Central Coast Quarter - Stage 1, Northern Tower (SSD-23588910)

Submissions Report

ATTACHMENT 1

Elevations & Sections
Sections - AA

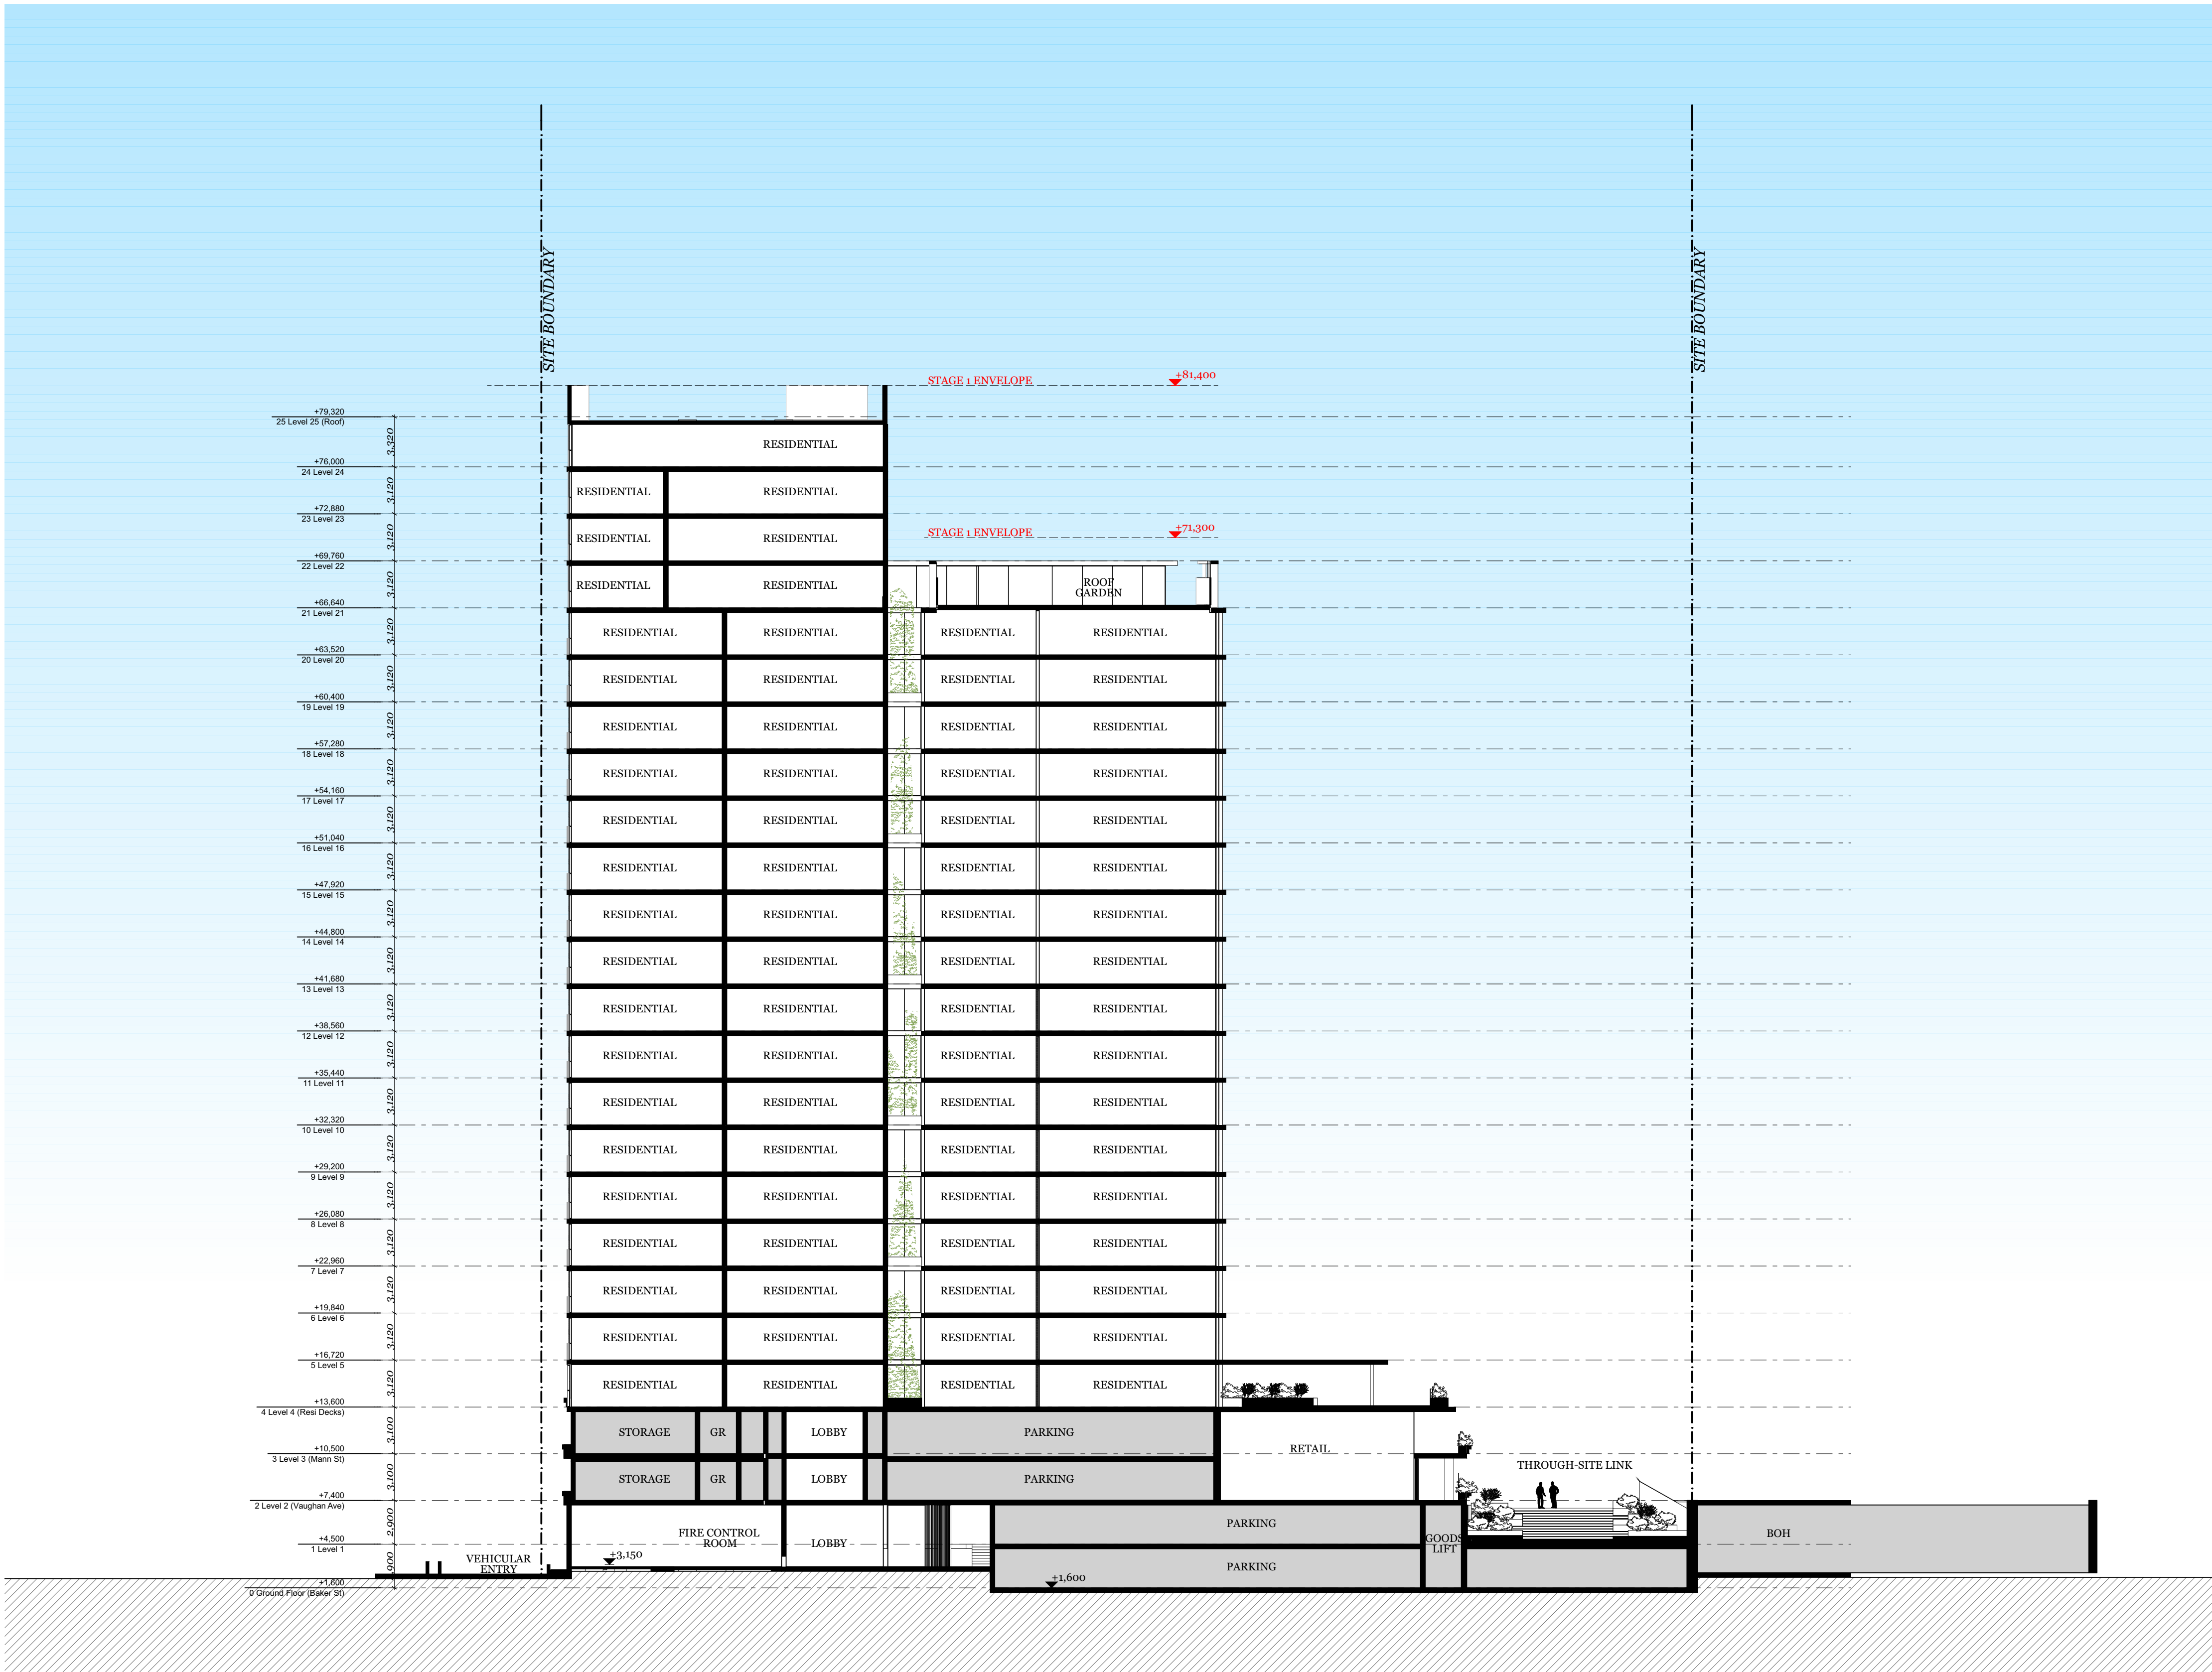
5. Clarify how podium level access will be provided from the stair core located at the eastern boundary of the podium roof level. In plan the drawings show a door at podium level, however, in section it is shown as an open staircase. In addition, clarify the maximum RL height of the stair core and if an open staircase is proposed confirm how water/weather ingress would be managed.

8. Update the VIA photomontage imagery to accurately reflect the current design of the development.
9. Update the architectural drawings to include an annotation of the maximum RL podium heights (i.e. at the podium parapet and podium stair core)
